22 November 2021

Access Logistics Park (SSD-17647189) – 884 Mamre Road, Kemps Creek

Western Sydney Airport Co (WSA) is writing in response to the public exhibition of the above State Significant Development Application (DA) at 884 Mamre Road, Kemps Creek (the site). We understand that the proposal seeks consent for the construction and operational use of a warehouse and logistics hub, which includes the following scope of works:

Drawing Title:
Landscape Sections CC & DD
 DWG No:

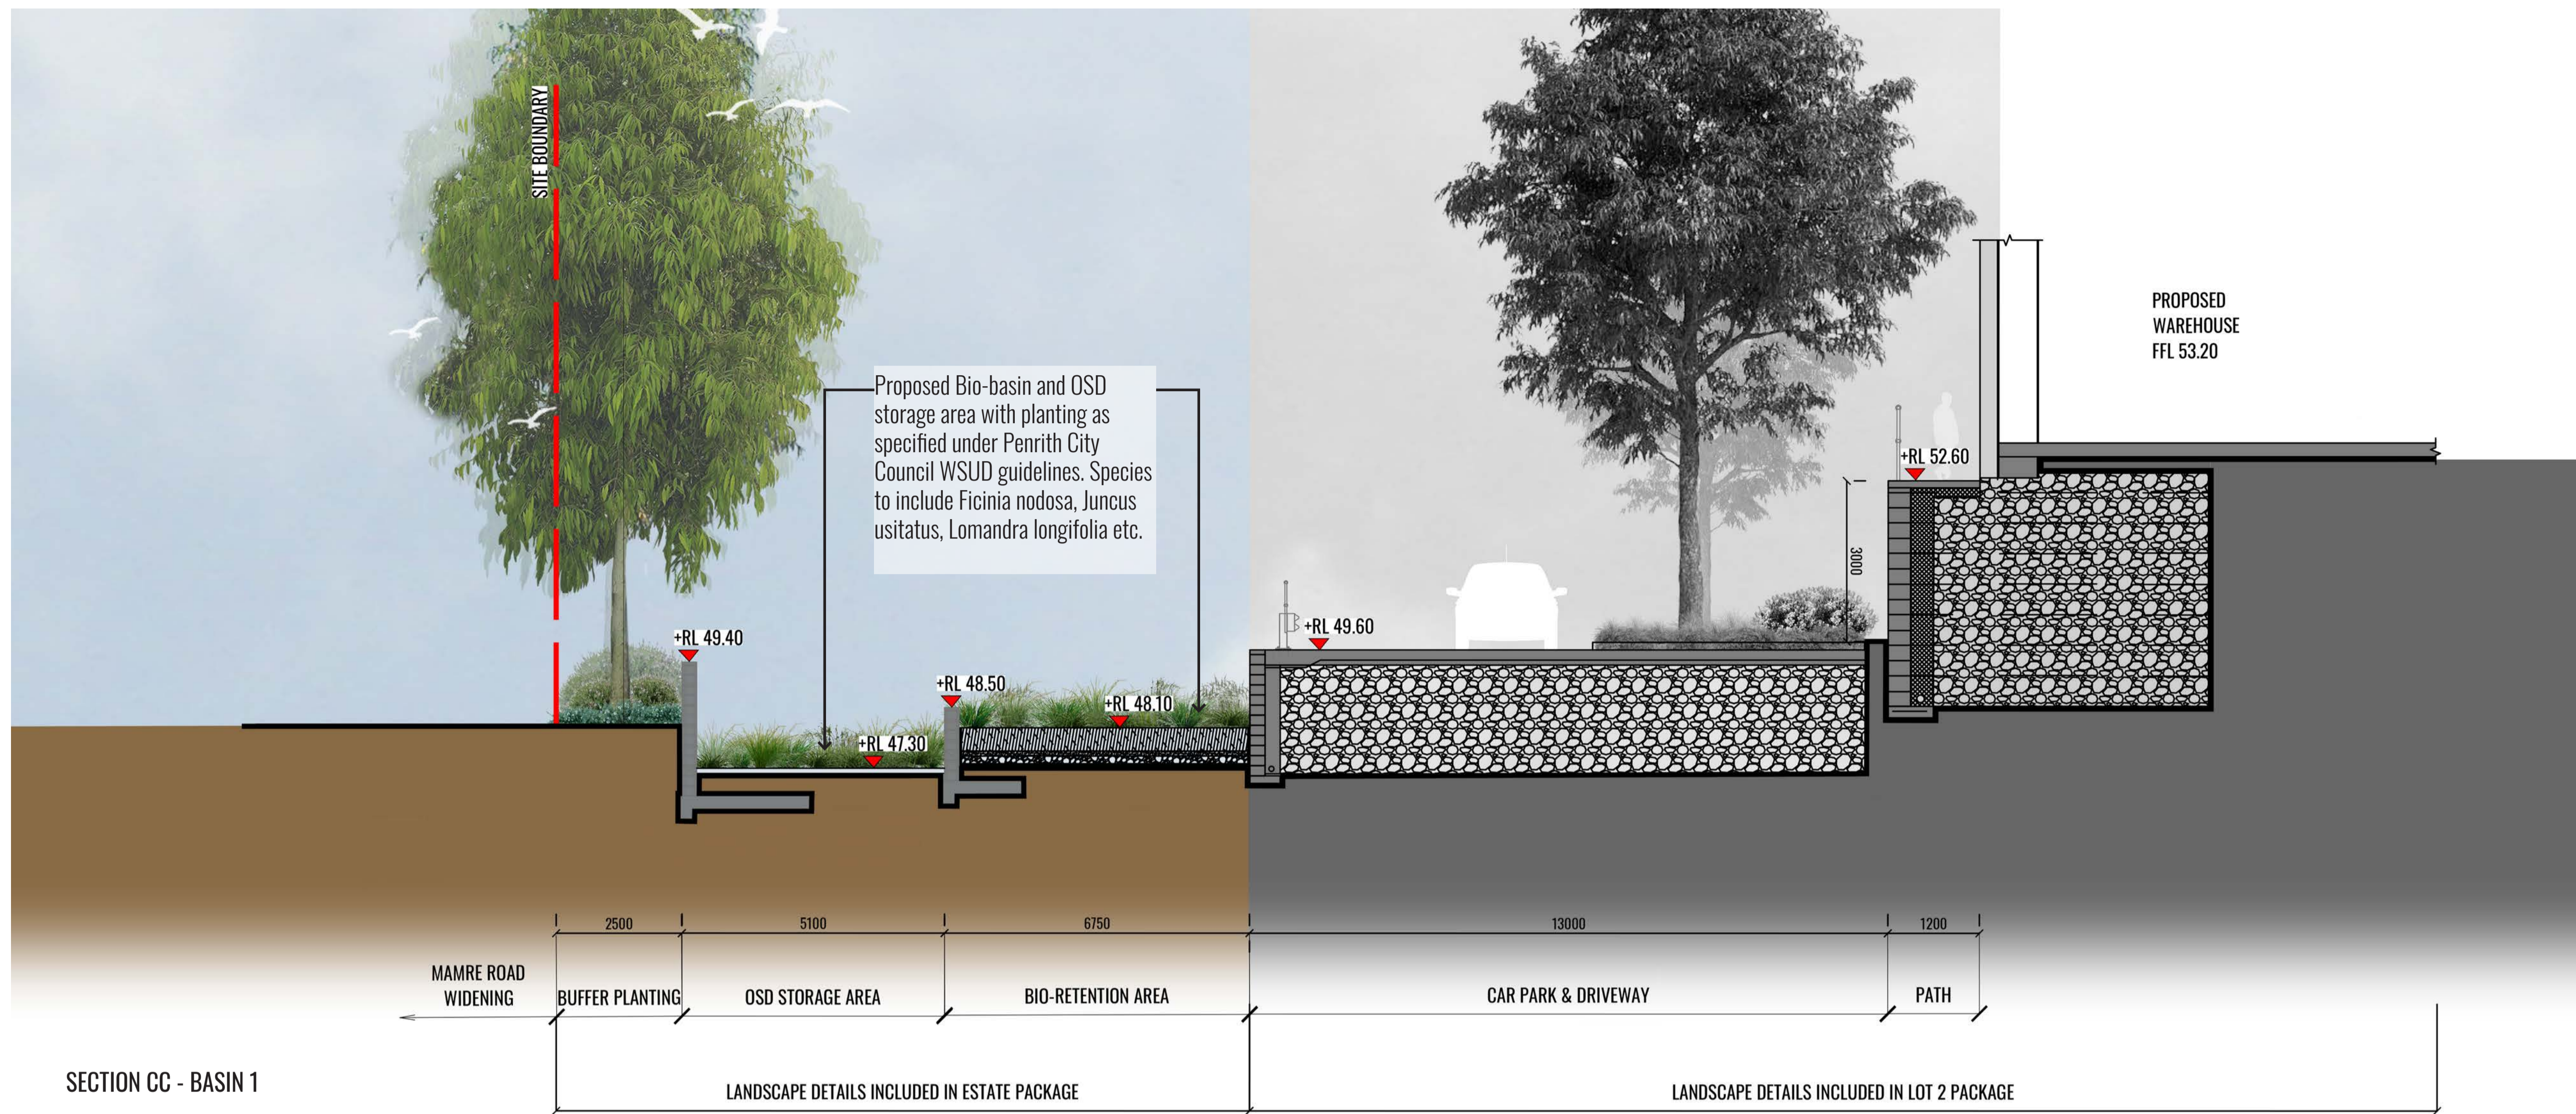
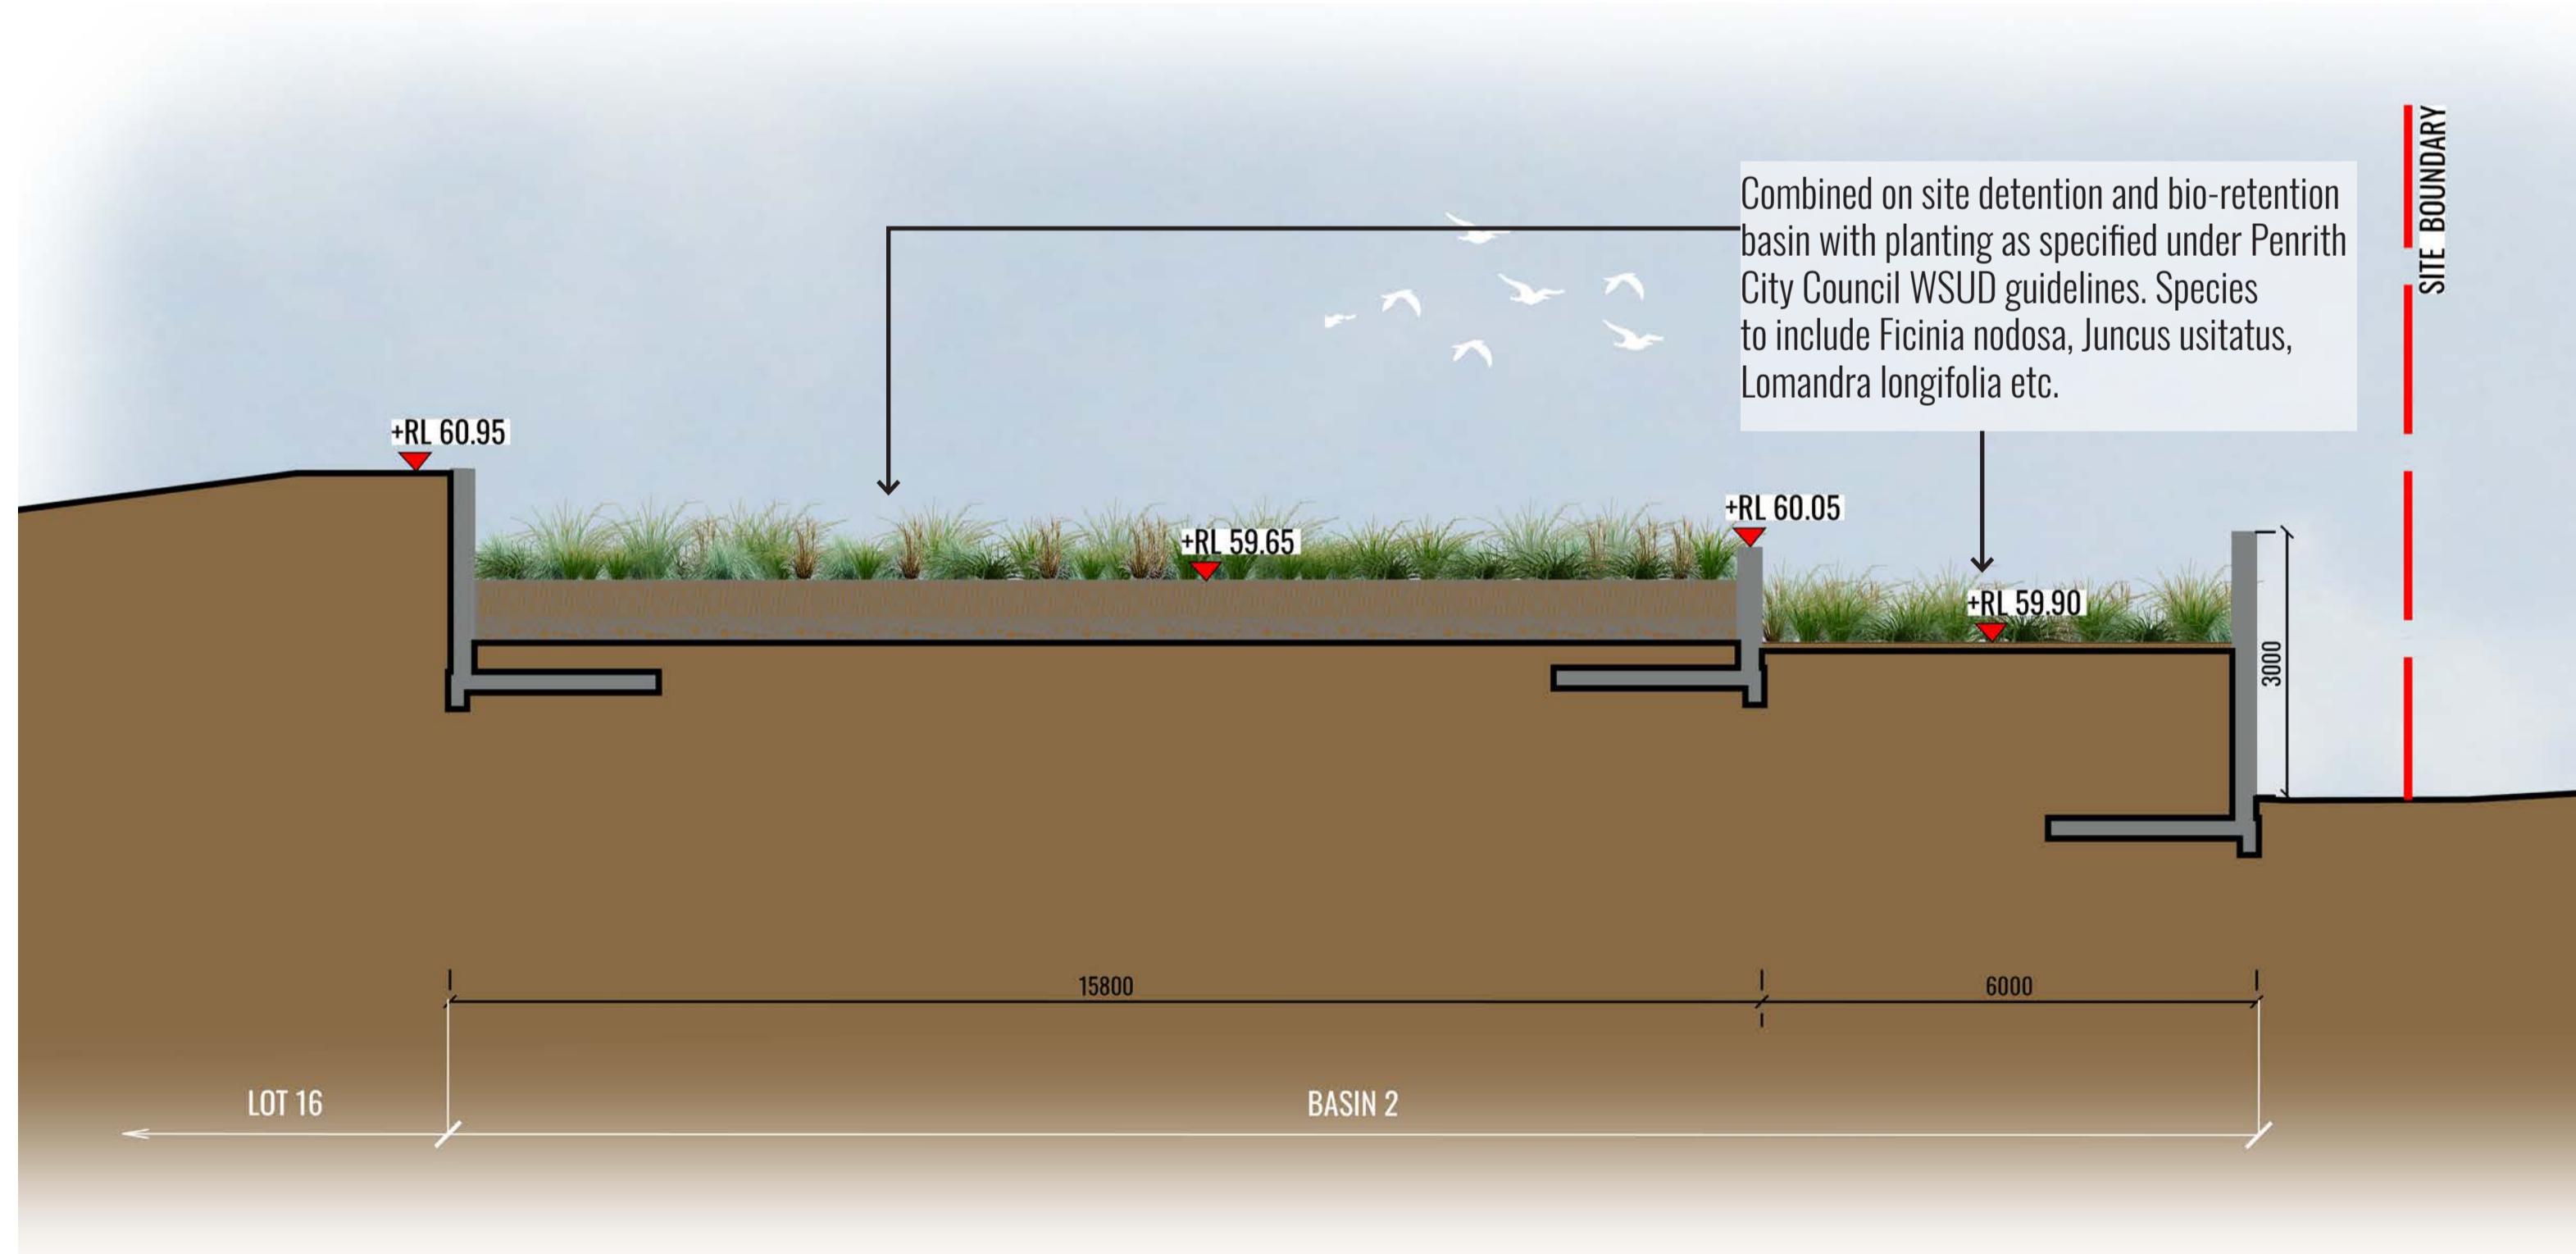
- landscaping proposed for the bio-retention basin, as well as the basin design itself;
- public and private domain landscaping, including along internal streets;
- waste management areas;
- grassing proposed on lots not proposed to be developed for this application.

WSA considers that further review of wildlife risk and associated management measures is required to ensure wildlife risk is minimised (e.g. through waste management, landscape species assessment).

Recommendation: Further assessment of the wildlife attraction from the proposal, and associated management measures is undertaken by the Applicant, to ensure that wildlife risk is appropriately mitigated. The additional wildlife risk assessment is to be provided to WSA for review.
